Your Ref: 2020/90119
Our Ref: W000665

17th September 2020

Former Petrol Station, North Road, Kirkburton, Huddersfield - Discharge conditions 12 (Drainage) and 13 (Water Supply Protection) on previous permission 2016/93935 for demolition of existing petrol station and erection of 4 retail and residential units (within a Conservation Area) (modified proposal)

Title: DRAINAGE LAYOUT			
Job No: 2242	DRN: MM	Date: 24/12/2019	
Scale: 1:125 (A1)	CHK: UD	DRG. No.: ESE-DR-S-001: P1

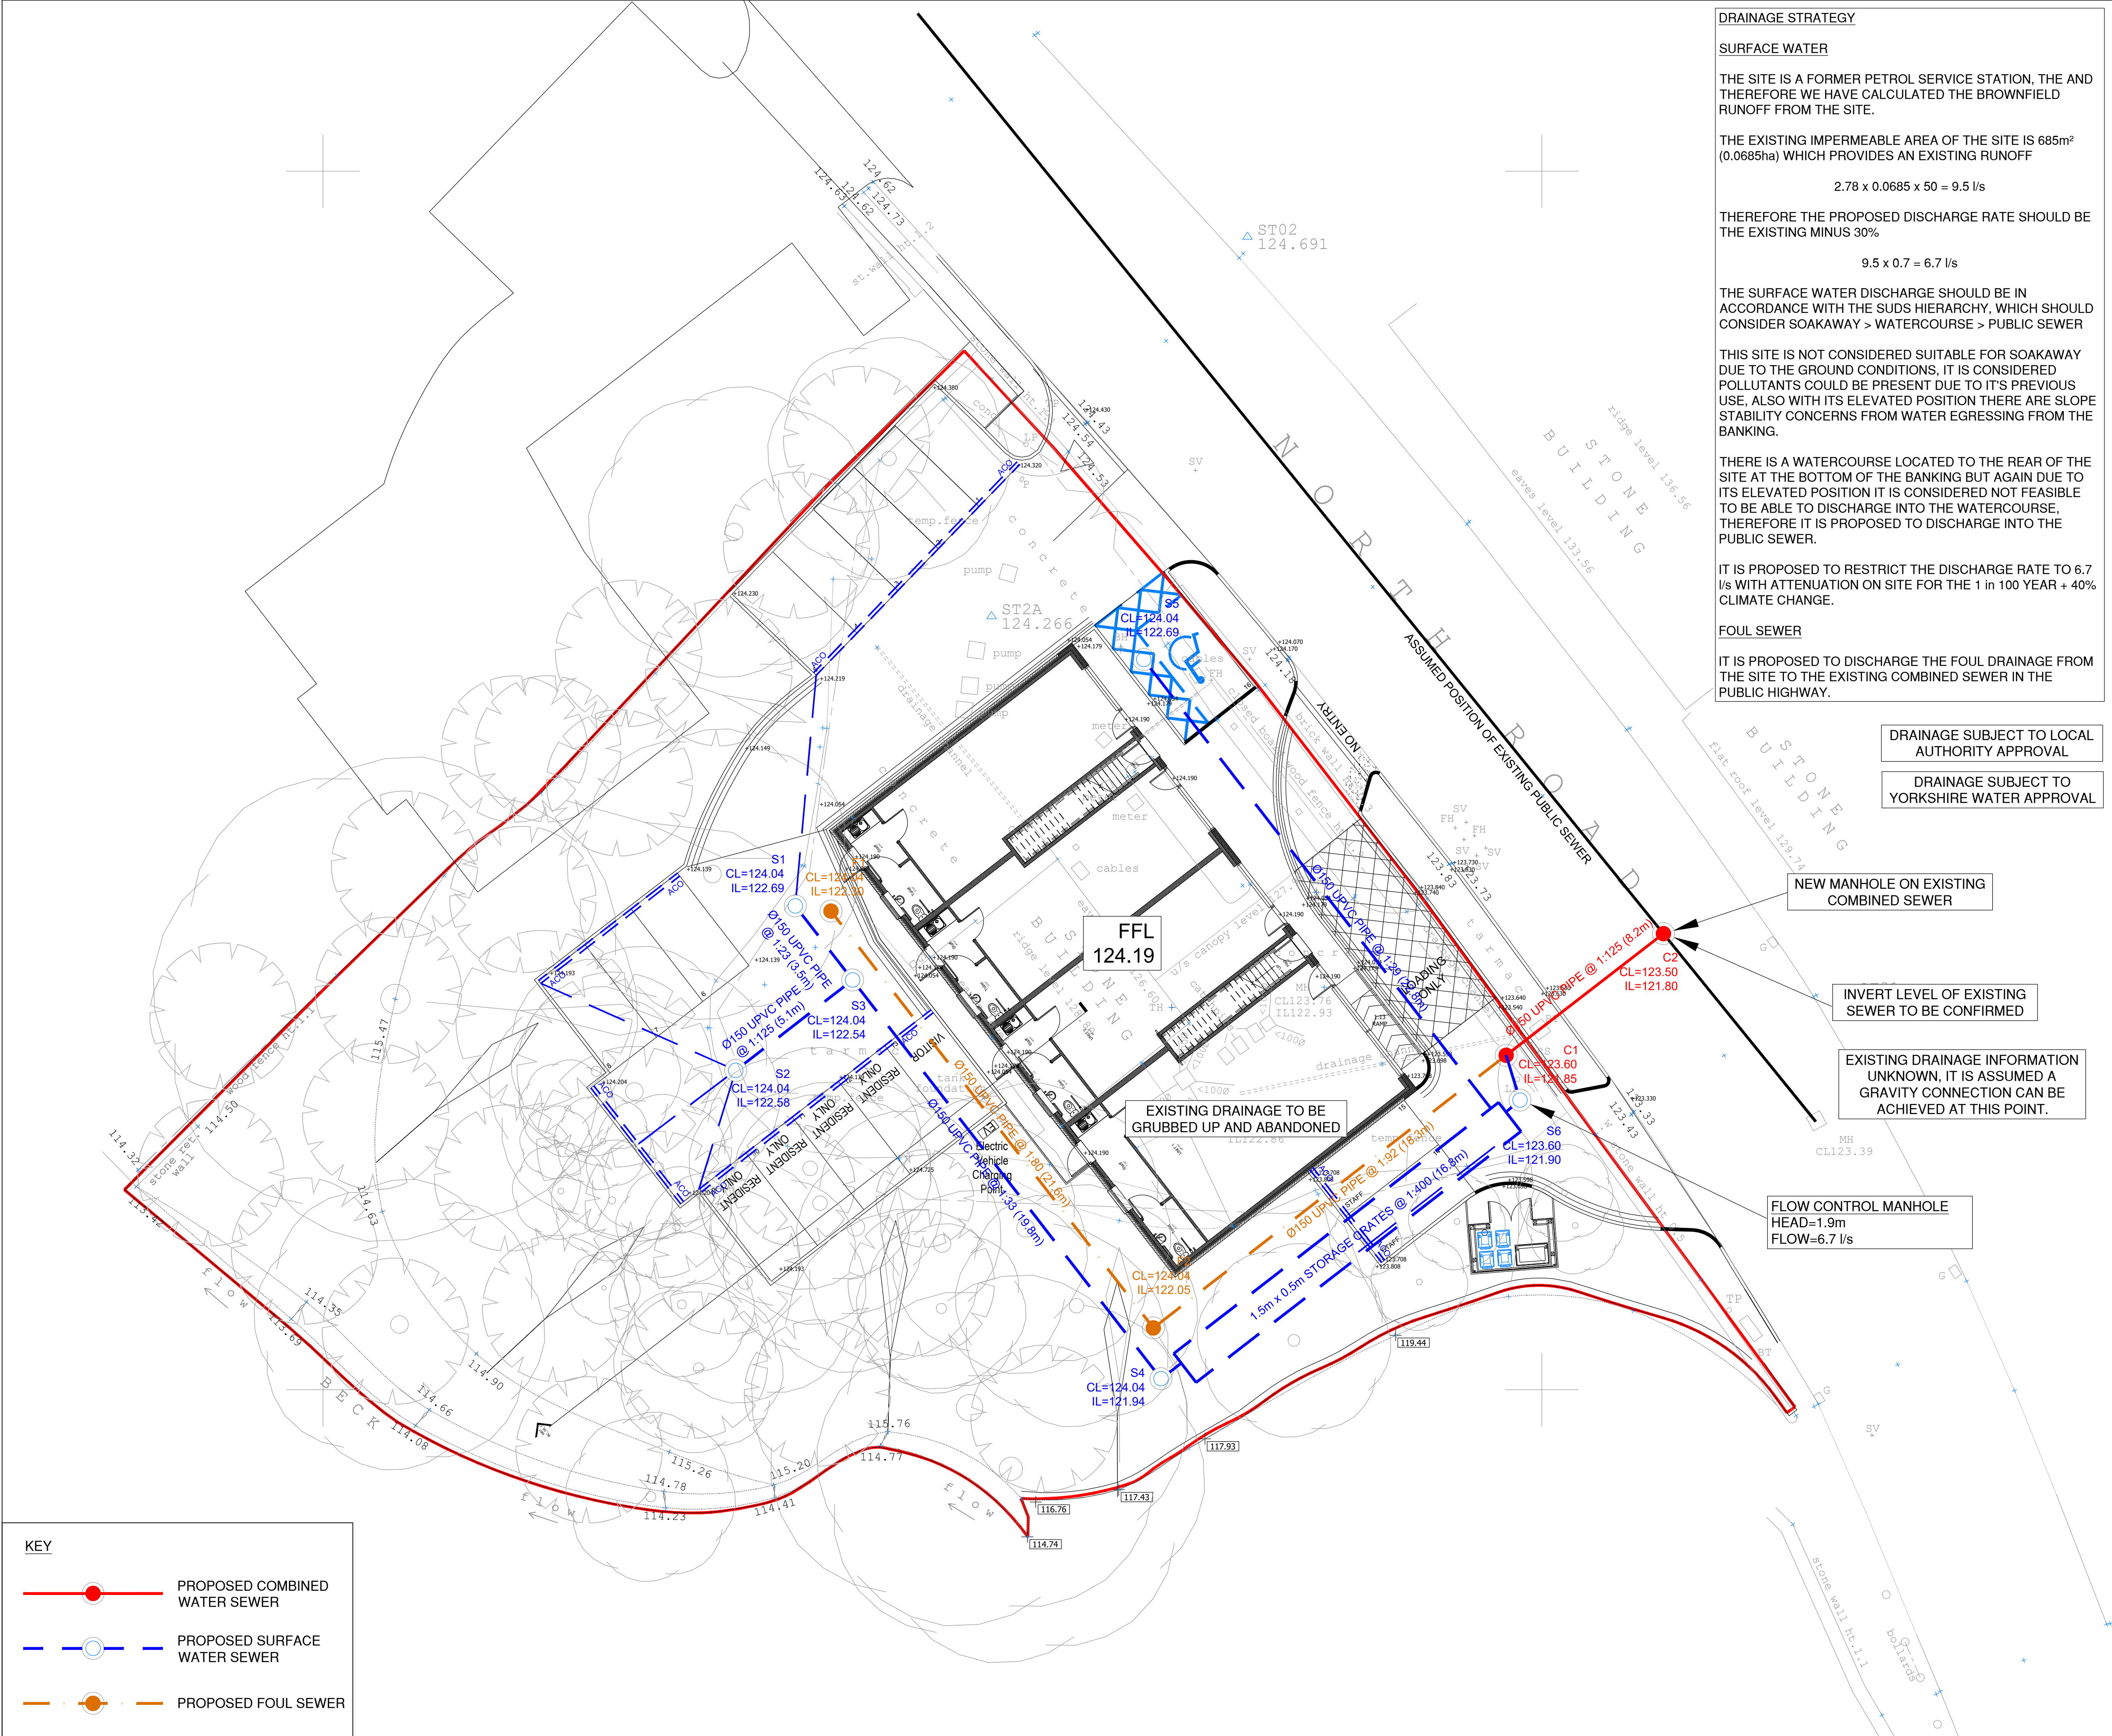
Based on the information submitted, Yorkshire Water still object to the discharge of condition 12.

- 1) From the submitted information, it is indicated that infiltration and discharging to watercourse cannot be utilised as a method of surface water disposal.
- 2) To decide on whether a discharge to the public combined sewer can be accepted, a full existing topographical survey is required. If positive connectivity from the existing site to the public sewer network can be proved highlighting all the existing impermeable areas draining to it, we can agree a rate based on this.

If no survey can be submitted, we will accept a maximum discharge rate of 3.5 (three point five) litres per second.
